REQUEST

Current Zoning: R-17MF LWPA (multifamily residential, Lake Wylie Protected Area)
Proposed Zoning: B-2(CD) LWPA (general business, conditional, Lake Wylie Protected Area)

Approximately 3.08 acres located on the west side of Sam Wilson Road, north of Performance Road.

The petition proposes to redevelop the site to replace one single family home with uses permitted in the B-2 district.

**EXHIBIT A**

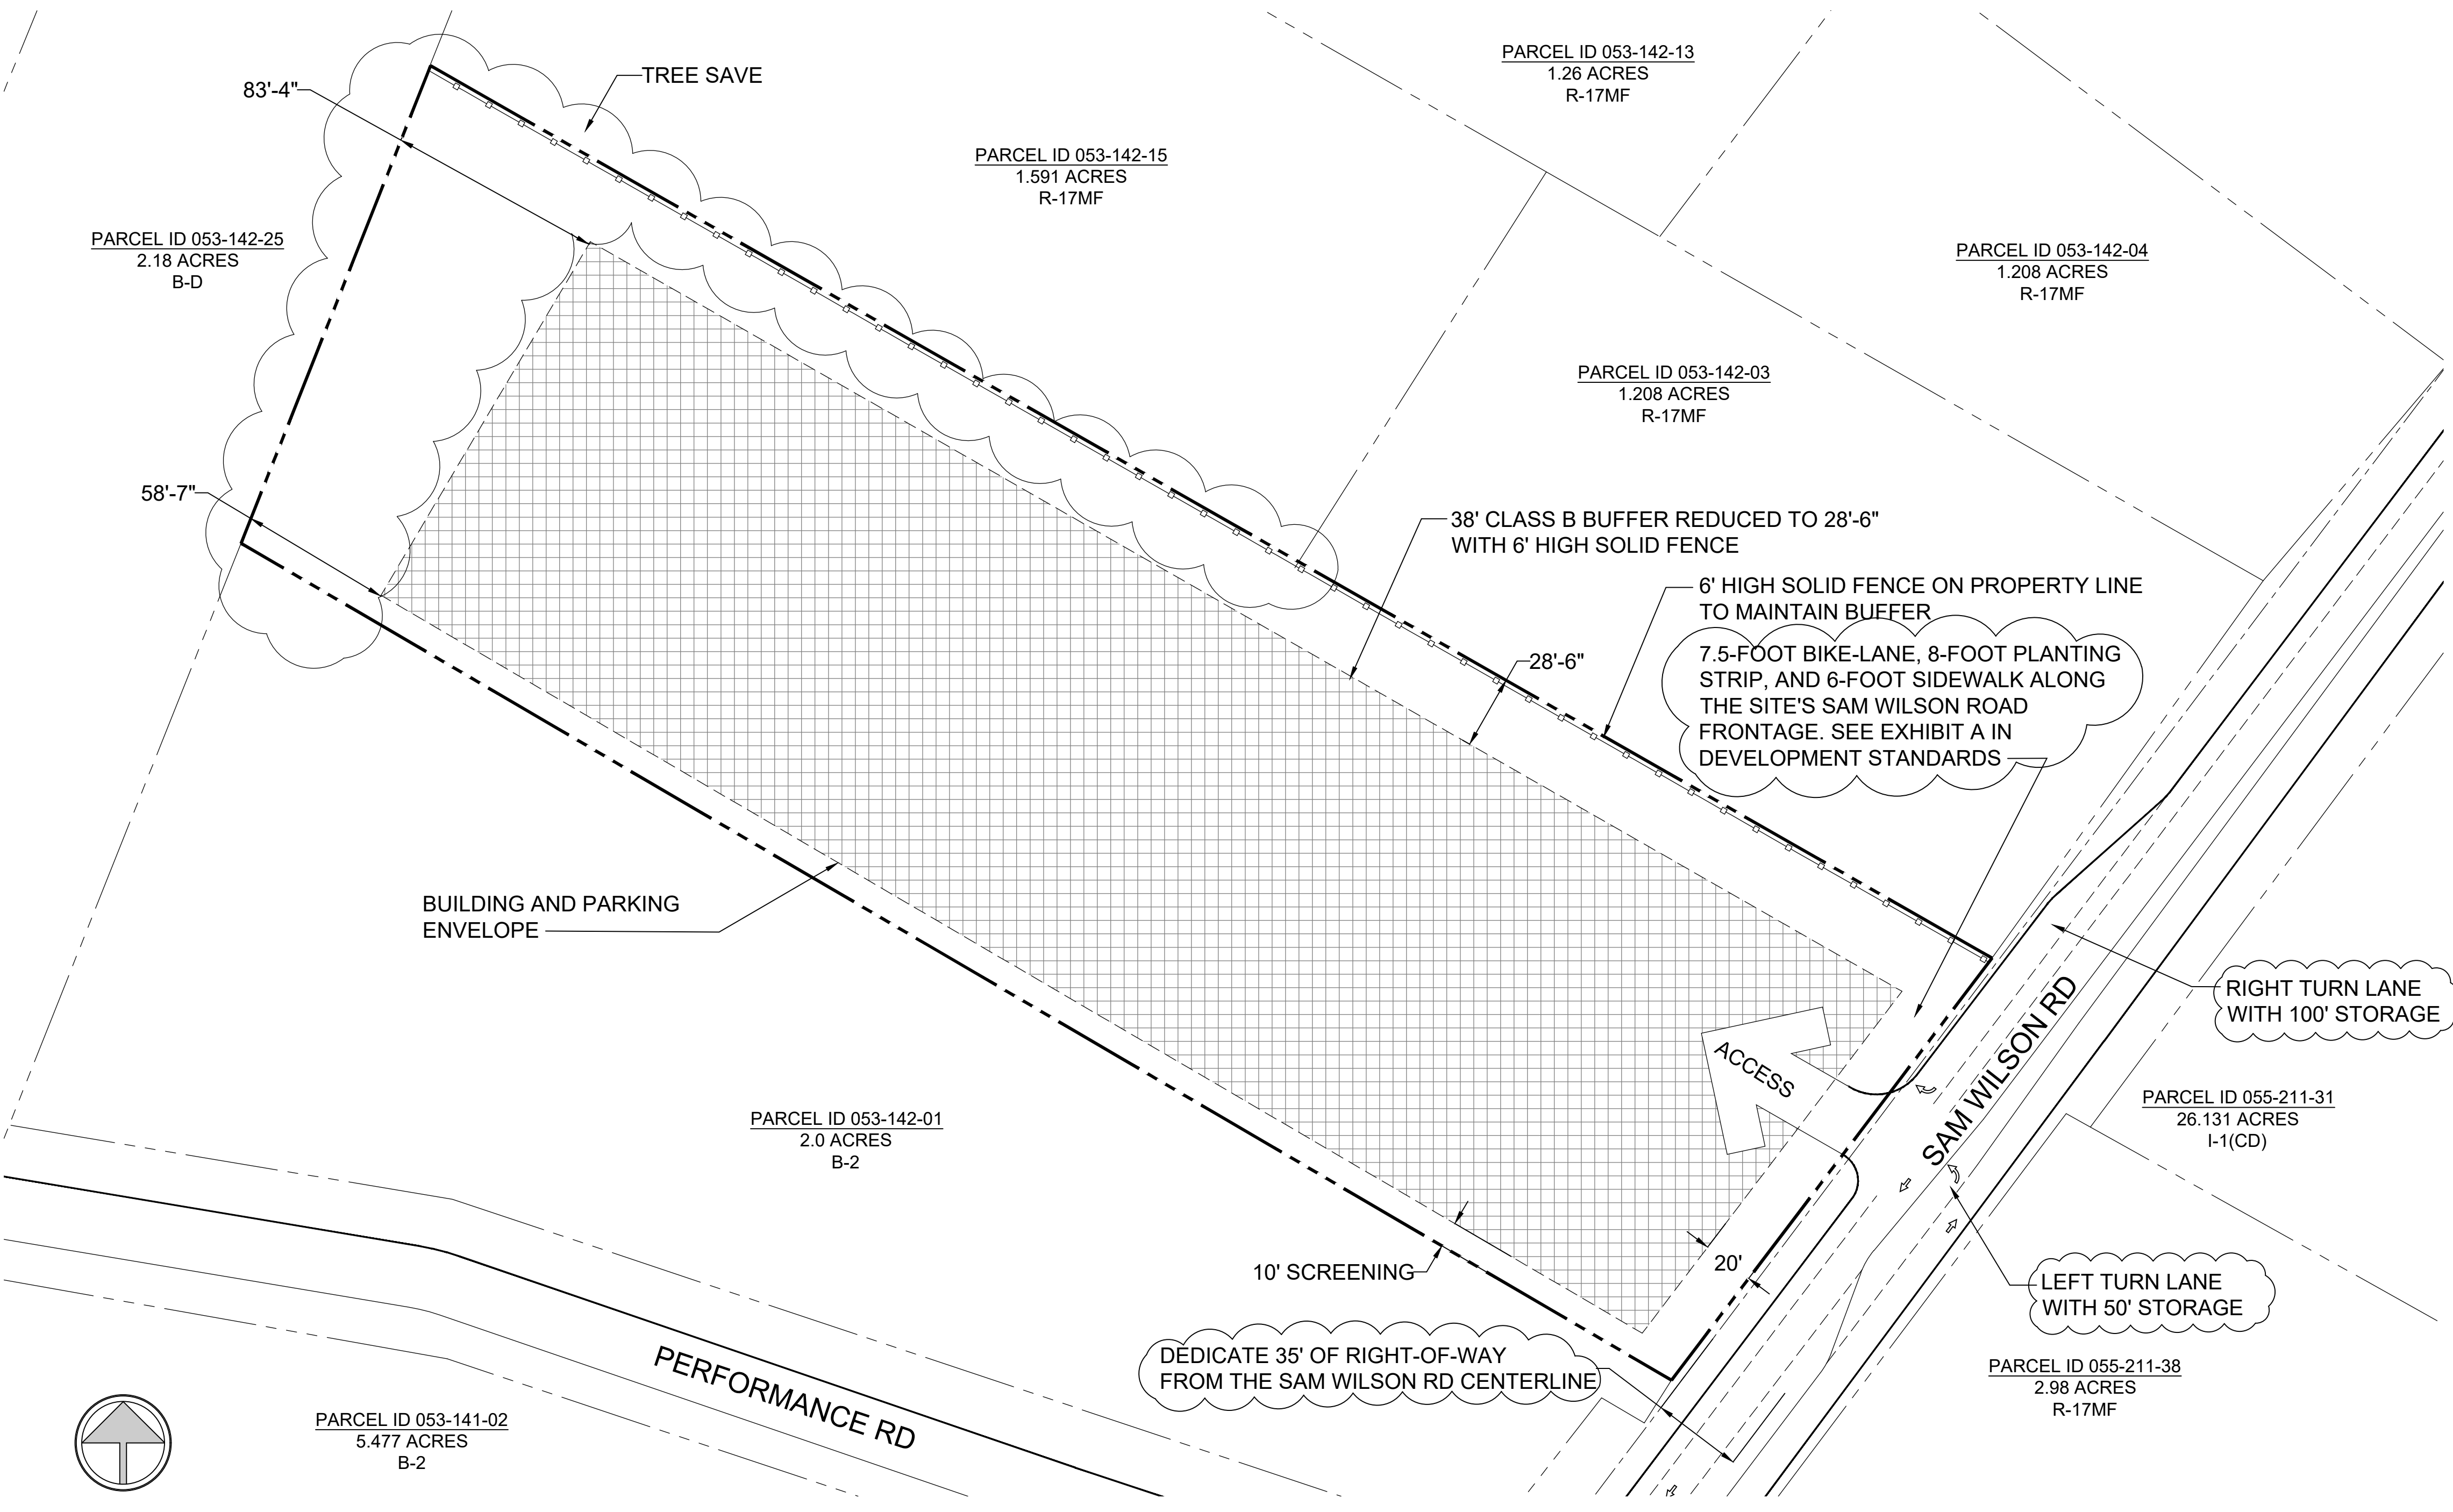
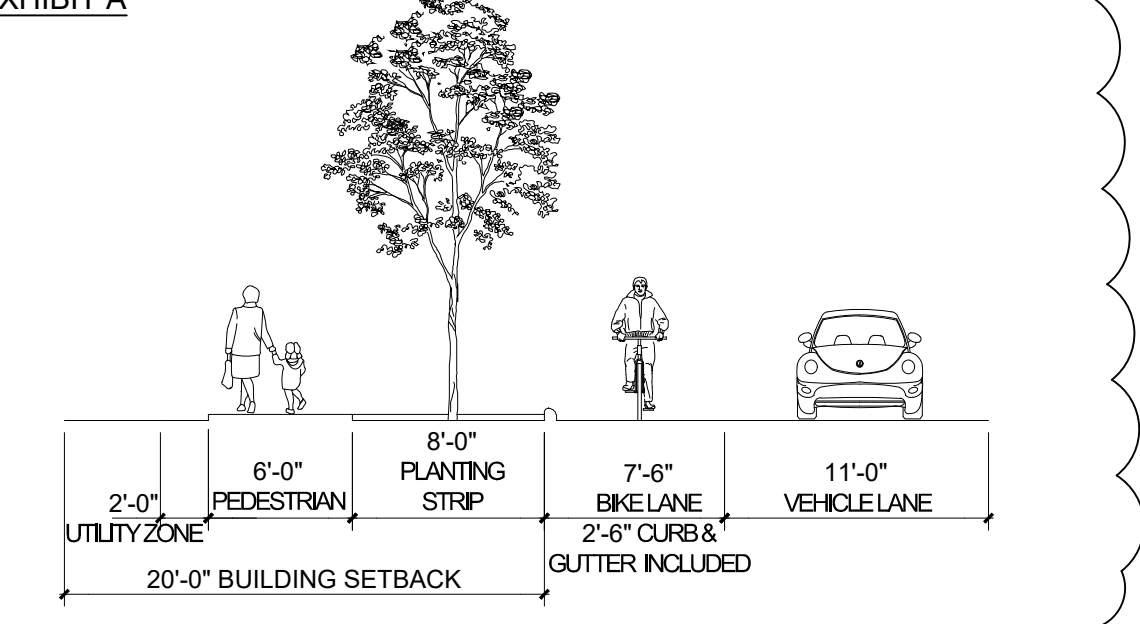
3. Label and dimension each item from the existing center line of Sam Wilson Road. **Update as a result of 12-29-2020 Site Plan:** Please label and dimension these items from the existing centerline of Sam Wilson. The right-turn lane affects the dimensions shown in Exhibit A (included in the site plan), therefore, the dimensions need to be clearly identified to ensure the infrastructure is constructed in the correct location.
- ~~4. Revise the site plan and conditional note(s) to include the construction of the cross section, as noted in the Catawba Area Plan, along the site's frontage on Sam Wilson Road. The bike lane, back of curb, planting strip, and sidewalk need to be labeled and dimensioned from the center line of Sam Wilson Road.~~ Addressed
